From: Kate Giddings <>
Sent: 12 April 2022 18:50
To: Amber Willard <>
Cc: Planning.Responses <>
Subject: BN/24/22/DOC - land at Angels Nursery, Yapton Road, Barnham, PO22 0AY

In relation to the above DoC, it is understood that plots 9-13 and 47-48 of this development have already been verified. Of the remaining plots which required remedial work, plots 3-4, 6-7, 14-15 (where an increased capping layer was required due to the presence of asbestos), 33-42 and 49 need to be verified. The above application relates to plots 7, 13-15, 38-39 and 49.

Eastwood and Partners' letter report (ref.: RAN/ME/44161-013, dated February 2022) which appears to relate to plots 13-15 and 39-39 has now been reviewed. It is understood that plot 13 has already been verified and is therefore not further considered. The submitted report contains no confirmation of the capping layer across plots 15 or 38, consequently these plots cannot be considered for discharge. In order for Environmental Health to consider plots 14 and 39 for discharge, please may the applicant provide the following information:

Section Through Proposed Capping Layer over Asbestos Affected Soil

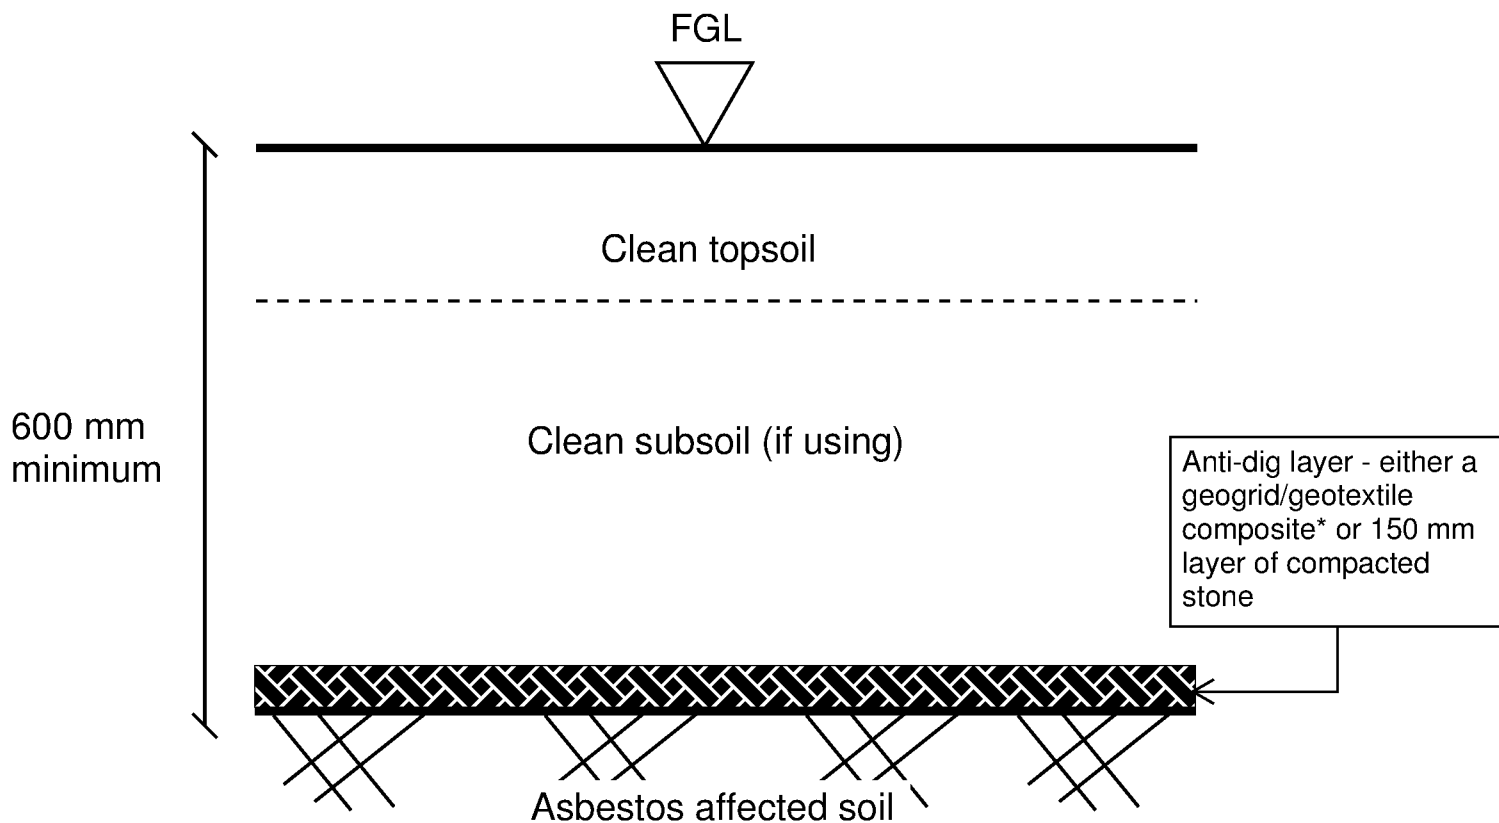
- details of the geotextile membrane and confirmation that this extends across the entire garden
- confirmation of the depth(s) of the soil samples.
